January 21, 2021

Re: Mountaintop Extracts Addn.
1912 1st St. NW
Traffic Circulation Layout
Engineer's/Architect's Stamp 1-7-21 (H14D113)

Based upon the information provided in your submittal received 1-19-21, the above referenced plan cannot be approved for Building Permit until the following comments are addressed:

1 HANDICAP PARKING SIGNS

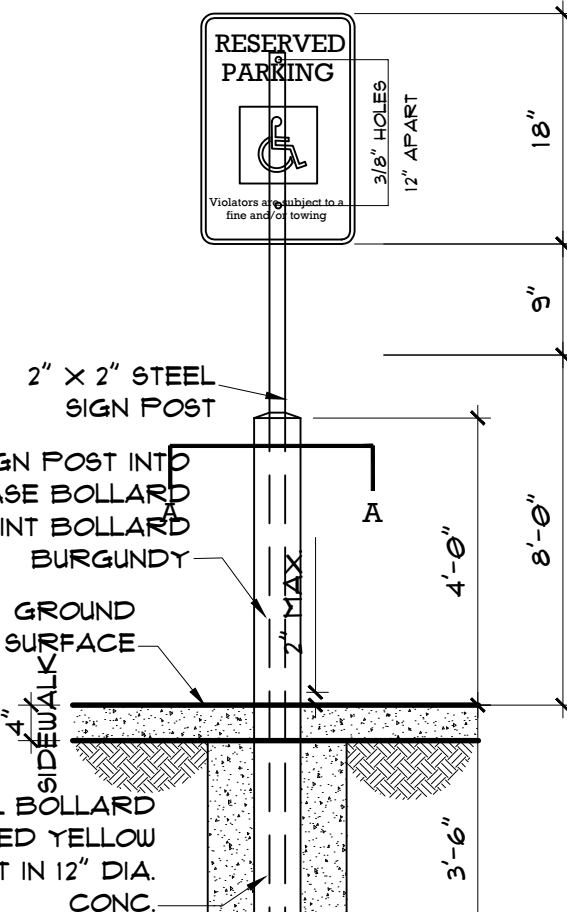
6. Van accessible aisles should be 8ft wide.
7. The ADA access aisles shall have the words "**NO PARKING**" in capital letters, each of which shall be at least one foot high and at least two inches wide, placed at the rear of the parking space so as to be close to where an adjacent vehicle's rear tire would be placed. (66-1-4.1.B NMSA 1978). Please add detail.
8. ADA curb ramps must be updated to current standards and have truncated domes installed.

3 BICYCLE RACK

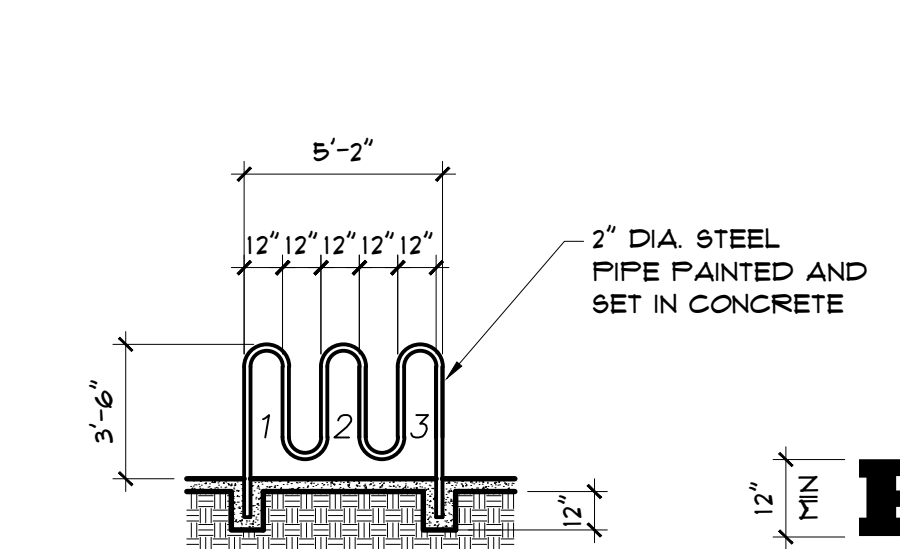
10. All bicycle racks shall be designed according to the following guidelines:
 - a. The rack shall be a minimum 30 inches tall and 18 inches wide.
 - b. The bicycle frame shall be supported horizontally at two or more places. Comb/toaster racks are not allowed.

- c. The rack shall be designed to support the bicycle in an upright position. See the IDO for additional information.
 - d. The rack allows varying bicycle frame sizes and styles to be attached.

- e. The user is not required to lift the bicycle onto the bicycle rack.
 - f. Each bicycle parking space is accessible without moving another bicycle.

11. Bicycle racks shall be sturdy and anchored to a concrete pad.
12. A 1-foot clear zone around the bicycle parking stall shall be provided.
13. Bicycle parking spaces shall be at least 6 feet long and 2 feet wide.

SITE PLAN

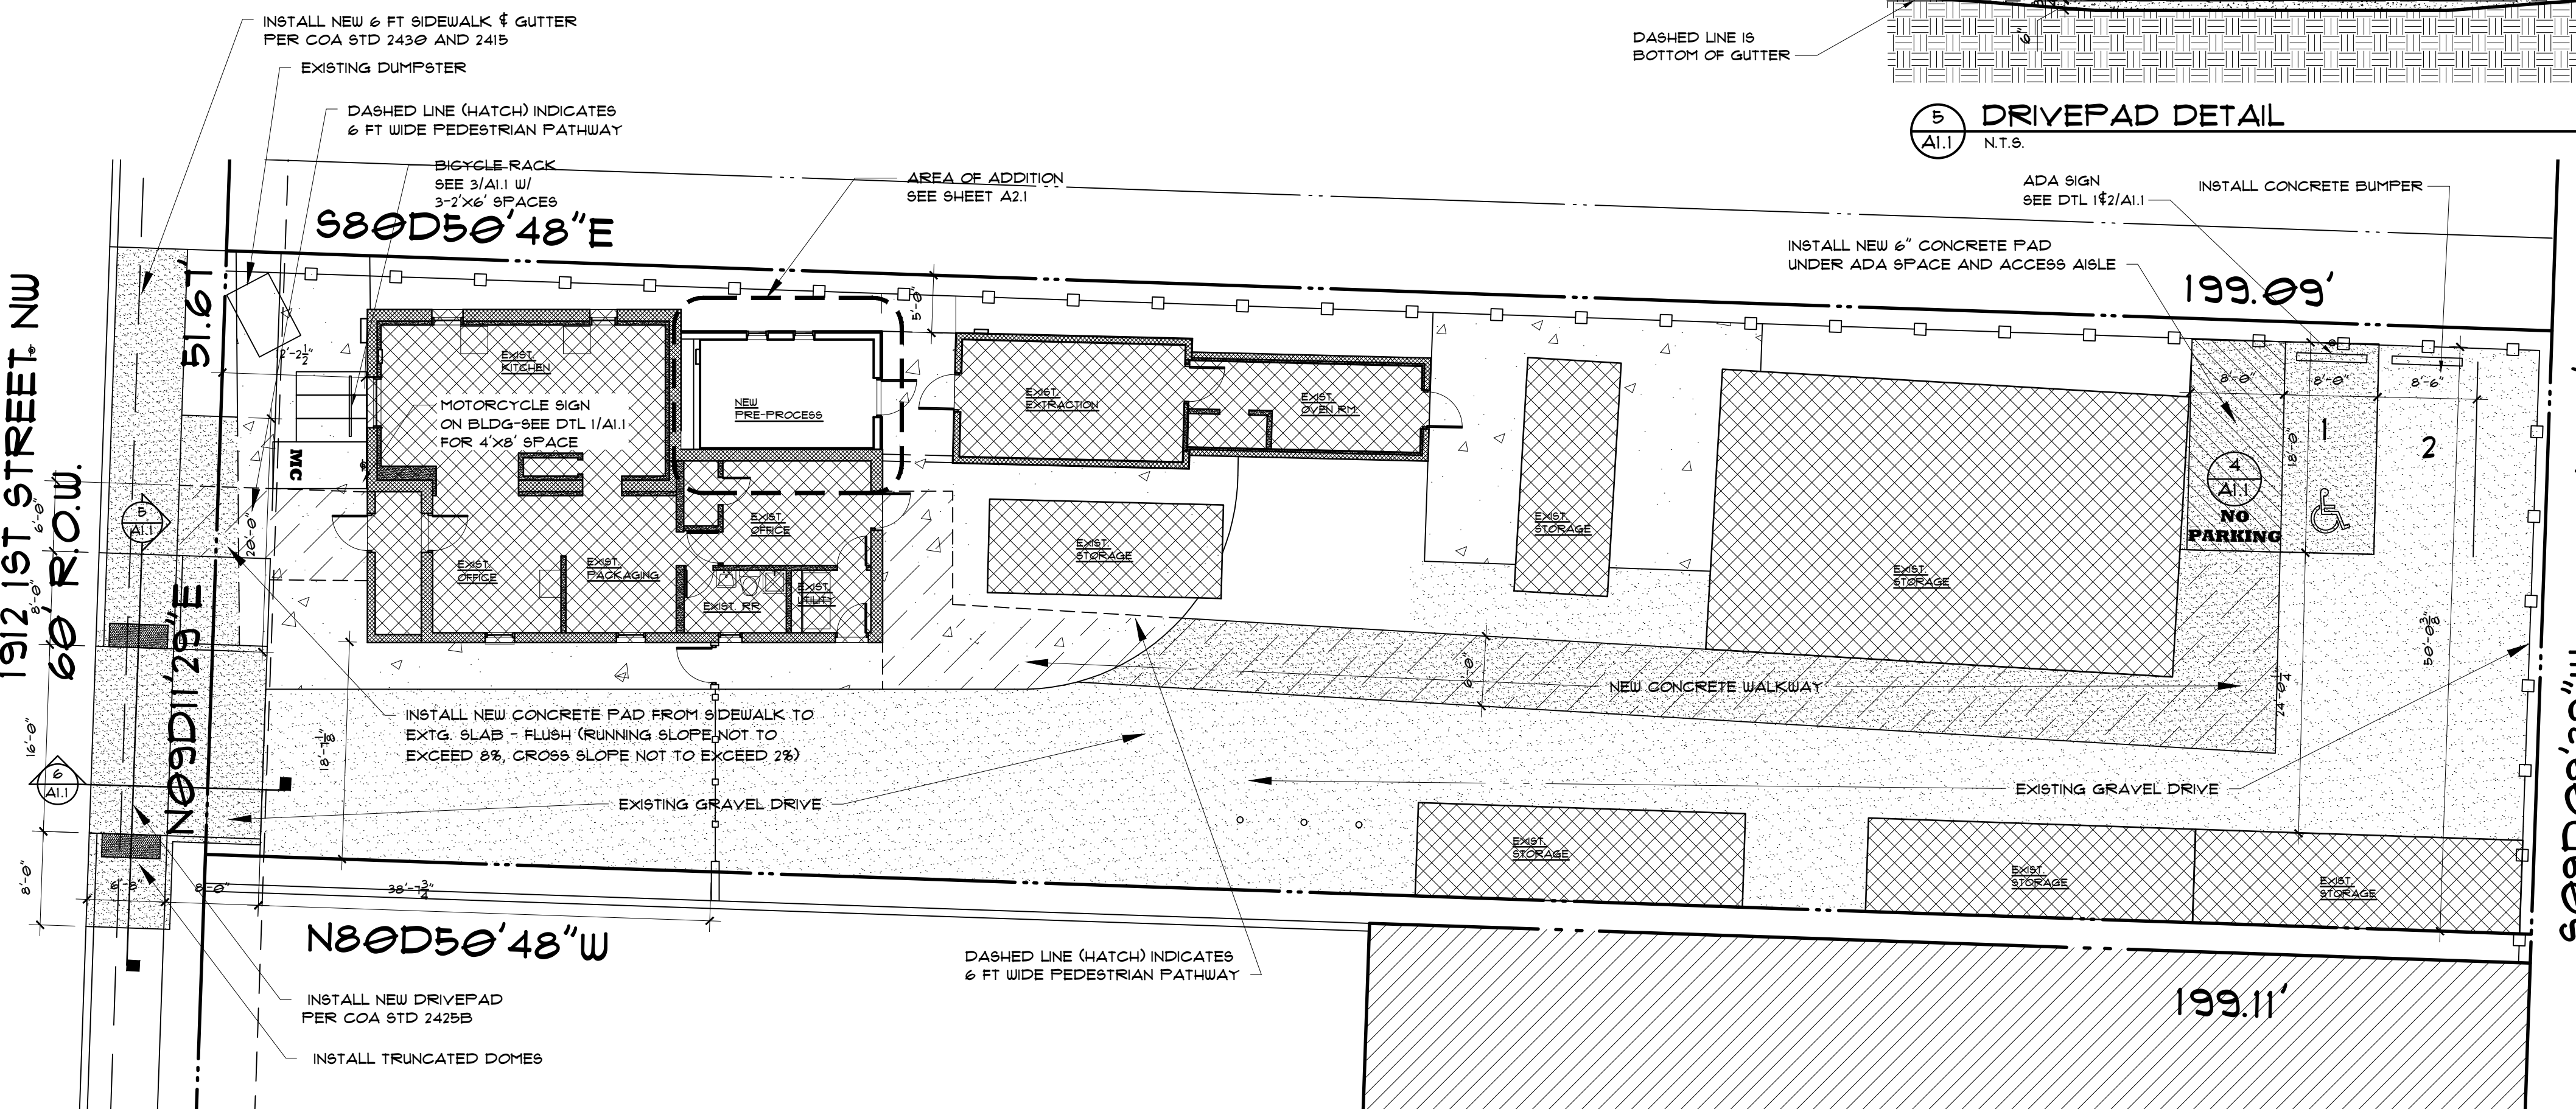
1. List the number of parking spaces required by the IDO as well as the proposed number of parking spaces including bicycle and motorcycle parking.
2. Please identify all existing buildings, doors, structures, sidewalks, curbs, drive pads, wall and anything that influences the parking and circulation on the site.
3. Please call out width of sidewalk. Sidewalk required along property line.
4. Please list the width and length for all existing and proposed parking spaces. Some dimensions are not shown.
5. The minimum parking stall dimensions are:

14. Per the IDO, a 6 ft. wide ADA accessible pedestrian pathway is required from the public sidewalk to the building entrances. Please clearly show this pathway and provide details.

15. Per DPM, a 6 ft. wide ADA accessible pedestrian pathway is required from the ADA parking stall access aisles to the building entrances. Please clearly show this pathway and provide details.

16. ADA accessible pedestrian pathway should not be placed behind parking space or adjacent to a vehicular way. Vehicle and pedestrian/wheel chair conflicts should be avoided as much as possible.

17. Provide a copy of refuse approval. Indicate location of dumpster
